**METHODIST LADIES COLLEGE – SSD 6484 MOD 1  
45 PARK ROAD, BURWOOD**

The modification application (SSD 6484 MOD 1) for the MLC Senior School Campus was publicly exhibited between 2 November and 15 November 2016.

In an email dated 24 November 2016, Burwood Council has questioned whether the proposed modification can be considered substantially the same development, and has raised some concerns regarding the proposed variation to the height and floor space standards contained in *Burwood Local Environmental Plan 2012* (BLEP 2012). This letter sets out the proponent's response to these matters. At the Department's request, this response focuses on Council's comments relating to substantially the same development. This response should be read in conjunction with the attached legal advice prepared by Addisons.

1 Main Building - Eastern Elevation - Park Road
 1: 200

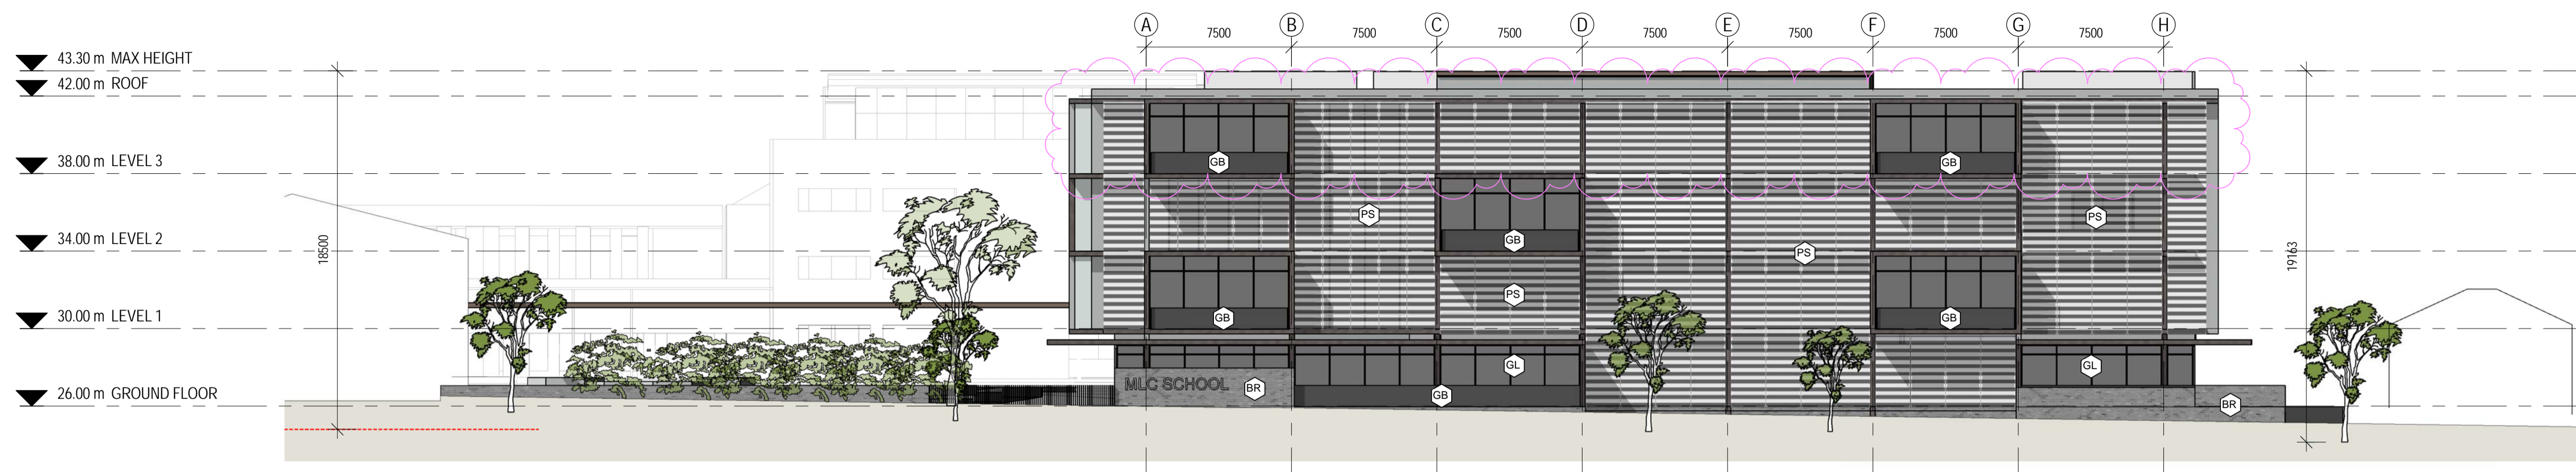
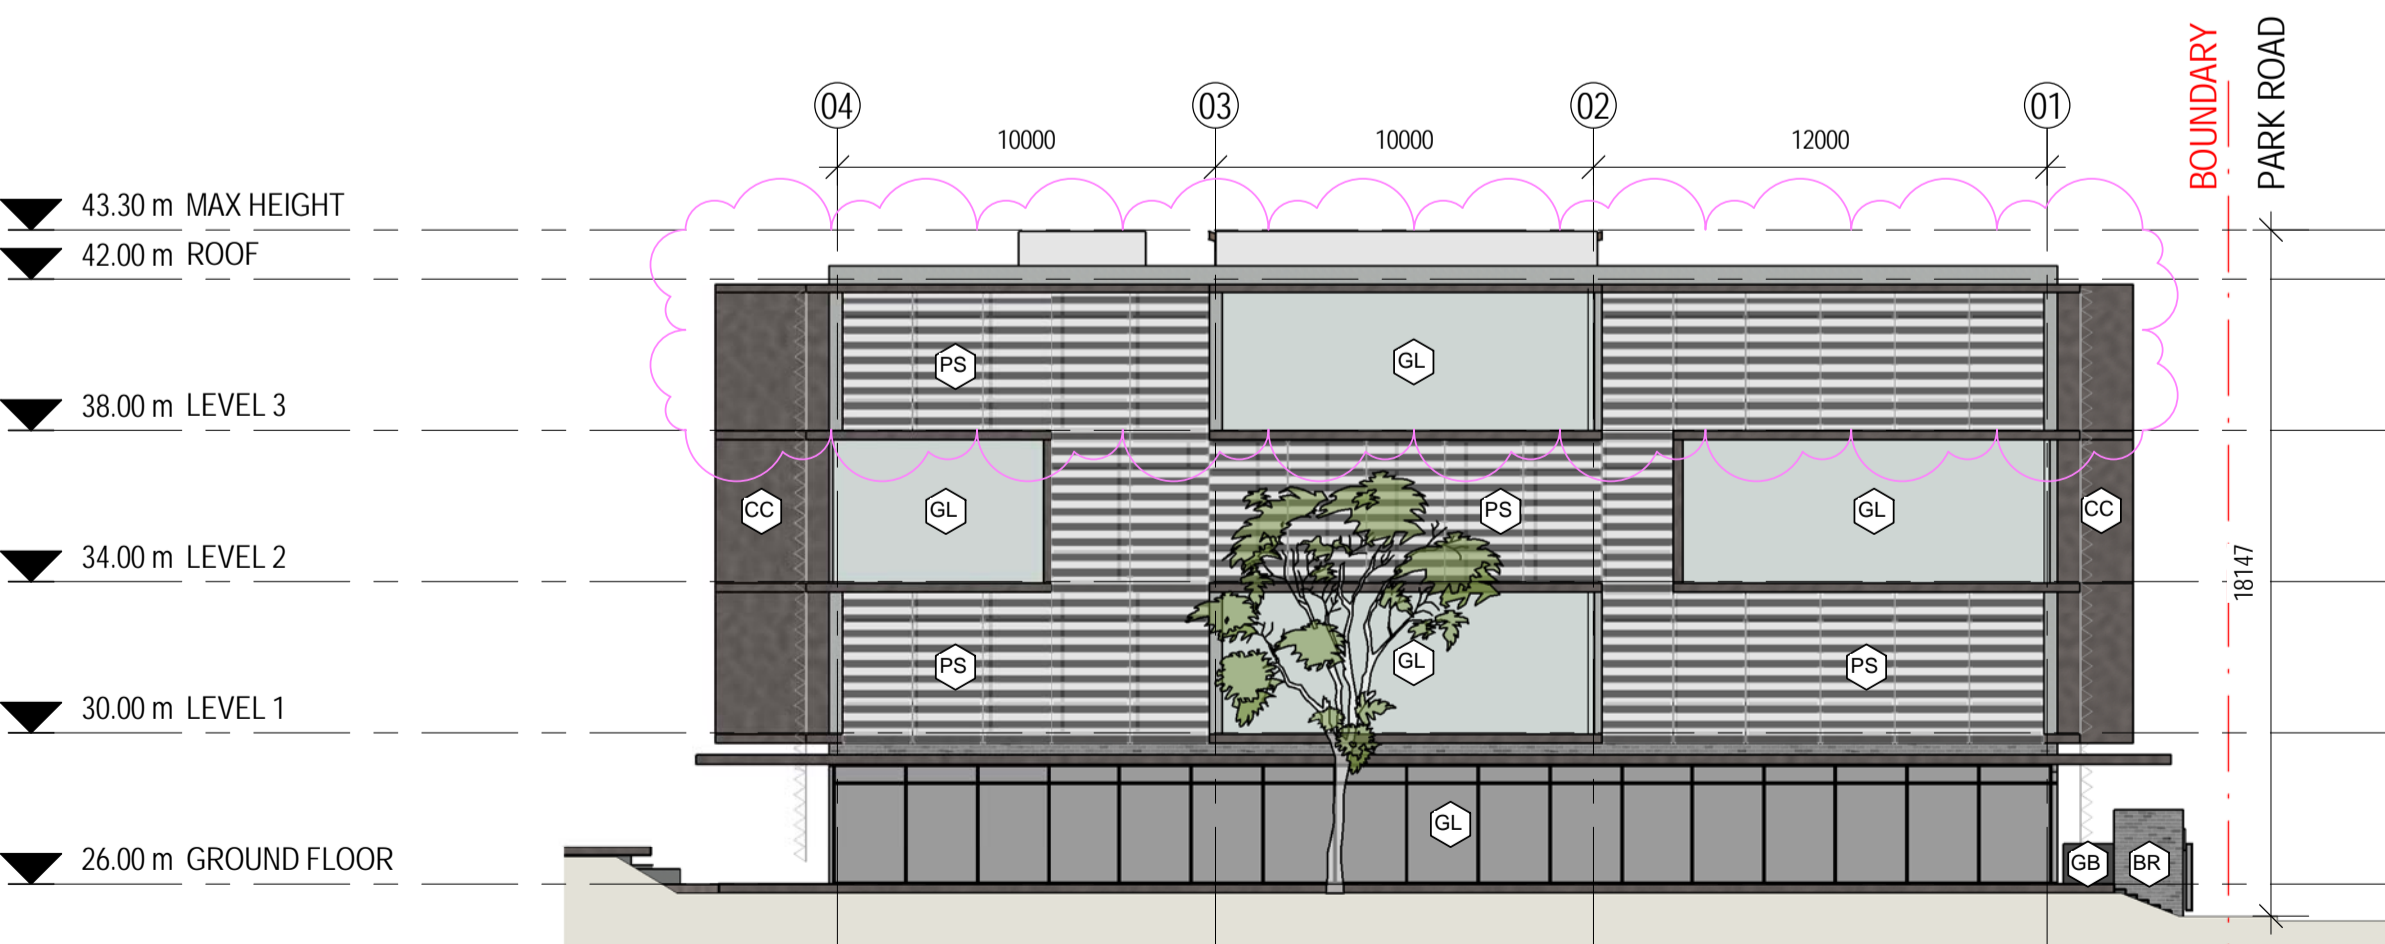
**The proposed height increase to the Teaching and Learning Building that takes the height from three (3) storeys to four (4) storeys radically changes the appearance of the building when viewed from Grantham Street and Park Road. Although the façade is similar in regards to materials and expression, it is considered the additional storey substantially changes the appearance of the approved building, particularly given the narrow setback to Park Road.**

**The use of Park Road is not limited to school related traffic and pedestrian activity. Accordingly, the proposed increase to the height of the building will result in undesirable impacts to the Park road streetscape**

Due consideration has been given to ensuring the appearance of the additional storey is consistent with the original building. The additional storey adopts an identical architectural expression and materiality to that of the approved development. Consequently, the additional storey appears as an integral part of the building. Furthermore, the proposal continues to appropriately address the street frontage of Park Road. The additional storey adopts the same setback as the approved Teaching and Learning Building, ensuring the siting of the building continues to be in keeping with the building line along Park Road. The visual impact of the building as proposed to be modified on the streetscape is not, in our opinion, considered to be substantially different to the approved building.

The additional impacts to the Park Road streetscape are considered minor for the following reasons:

- as illustrated in the shadow diagrams provided at Attachment A of the modification application, the additional shadow impacts are minor, occur only in the late afternoon and fall only on the school's outdoor space;
- there is no change to student and staff numbers and therefore no additional traffic impacts;
- the additional storey to the Teaching and Learning Building will appear as an integral part of the approved building and not substantially change the appearance of the building when viewed from the streetscape;
- whilst the additional bulk and height will not be concealed, landscaping and a landscape buffer to the residential uses located east of the site will soften the appearance of the building within its setting; and

- whilst Park Road does accommodate some through traffic to Parramatta Road and Burwood Town Centre, the road is predominantly used by school related pedestrian and vehicle traffic, and is located within a locality which has an institutional school character.
